Our Case Number: ABP-318802-24

Re: Proposed development of a resource recovery centre (including waste-to-energy facility) in Ringaskiddy, County Cork.

Observation on SID Application

Case Reference: PA04.318802, Ringaskiddy, Co. Cork
Proposed Development: Resource Recovery Centre (including waste-to-energy facility)
Applicant: Indaver NV t/a Indaver Ireland

Figure 8.5 Terrain Near Ringaskiddy RRC, Ringaskiddy, County Cork

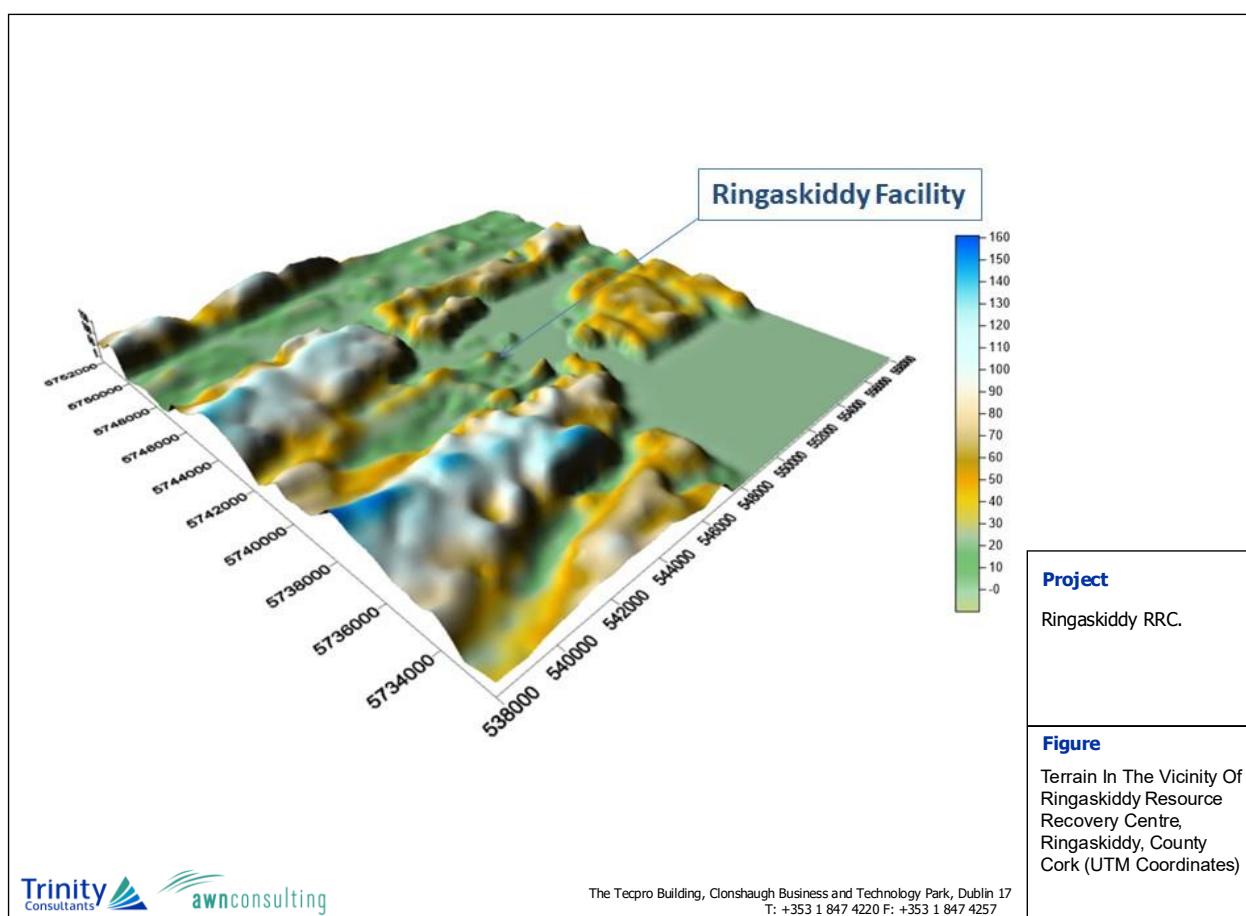
Further to point 8 above, the extent of the visual envelope presented in EIAR Figures 11.0a (visibility of top of building) and 11.0b (visibility of top of stack) does not incorporate a visible thermal plume. This element has been under-described and under-assessed in the EIAR.

The wide, flat topography at Poolbeg and Carranstown WtEs means neither site is overlooked from a height. This hugely contrasts with the elevated views over Ringaskiddy from Cobh and Rushbrook. It will place 1000s of Cobh and Rushbrook residents living at eye-level or over-looking the top of the stack.

The elevated topography of the southwestern aspect of Great Island is also demonstrated in Appendix 8, Figure 8.5 terrain model.
